**Amended Concept Proposal for Cockle Bay Wharf Redevelopment (SSD 7684) –
Response to Submissions**

CD18/06566

TAB A – Suggested Conditions of Consent

### Precinct Bicycle Connectivity

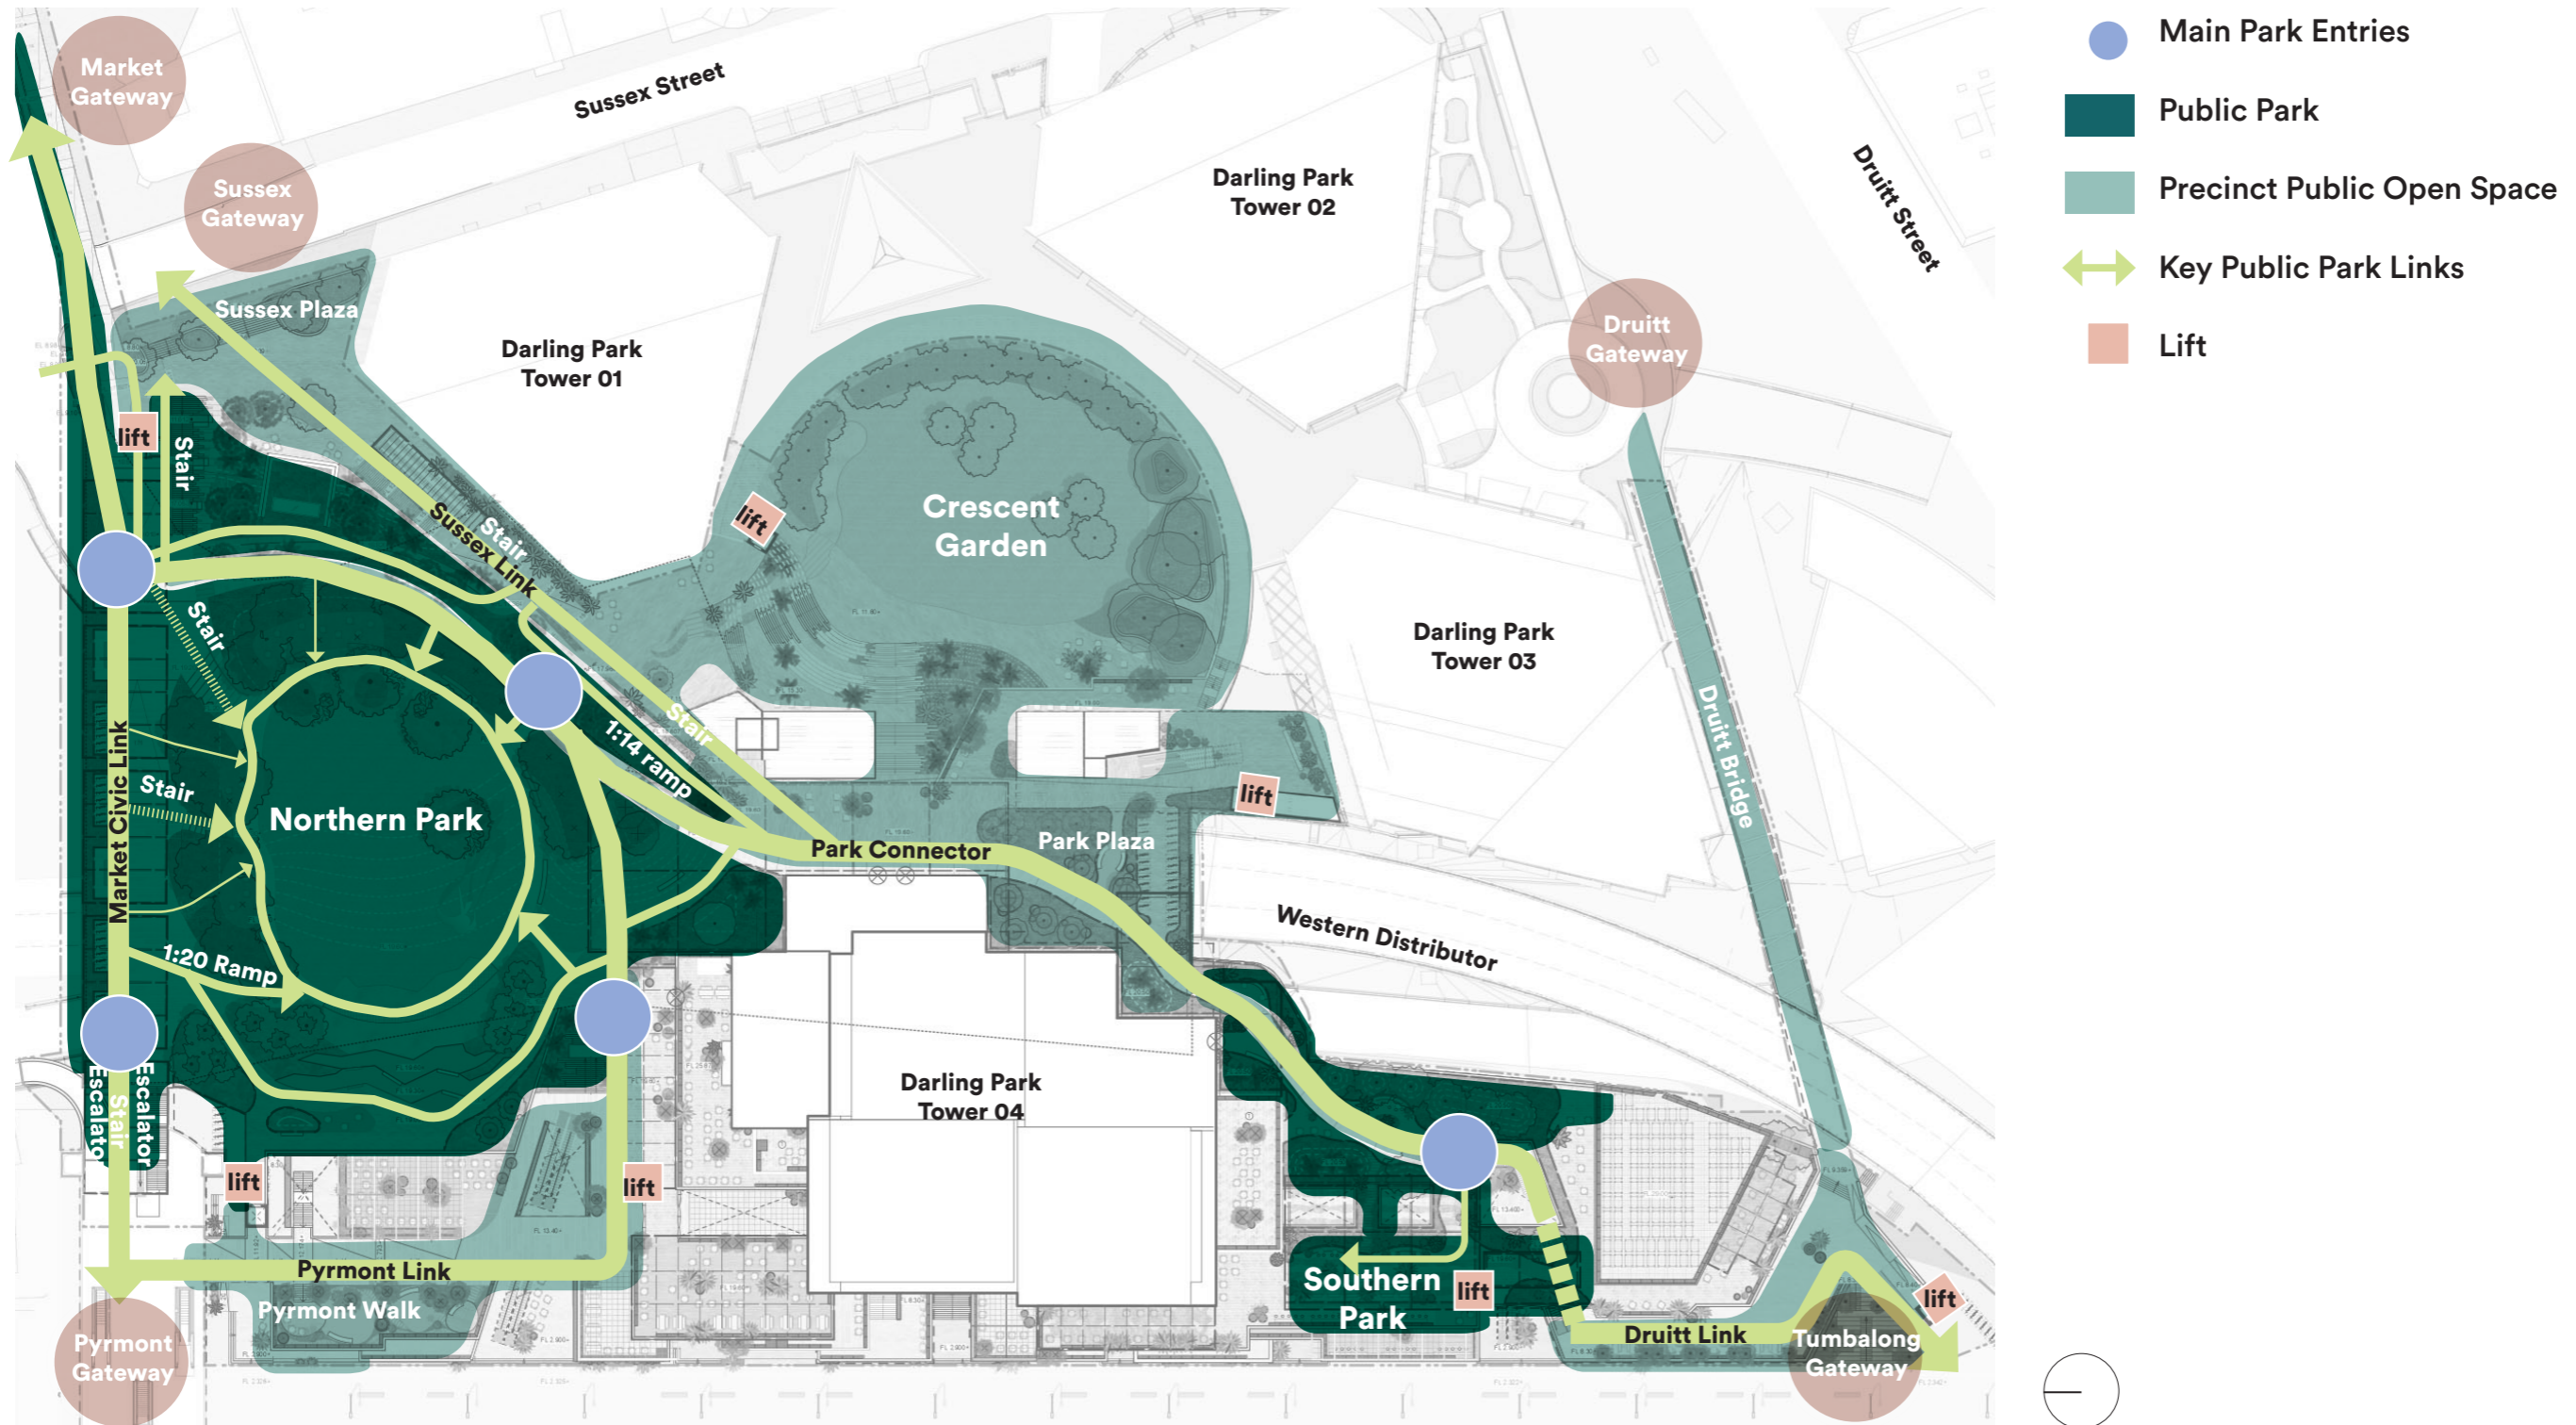
TfNSW also advised that the development site's location provided it with a unique opportunity to improve cycleway connections between Pyrmont/Bays Precinct and the CBD by connecting the existing pedestrian/cycle infrastructure on the Western Distributor with the King Street and Kent/Liverpool Street cycleways. TfNSW requested that the applicant consider connecting existing pedestrian/cycle infrastructure accordingly.

- Improvements to the Druitt Street Bridge entry access point from the Darling Harbour waterfront and the remainder of the route between the development site and Sussex Street, including increased pedestrian capacity to accommodate workers and visitors in the Darling Harbour Precinct, including during events, in consultation with the Sydney Coordination Office within TfNSW; and
- A cycleway connection between existing pedestrian/cycle infrastructure on the Western Distributor and the King Street and Kent/Liverpool Street cycleways via the development site, in consultation with the Sydney Coordination Office within TfNSW.
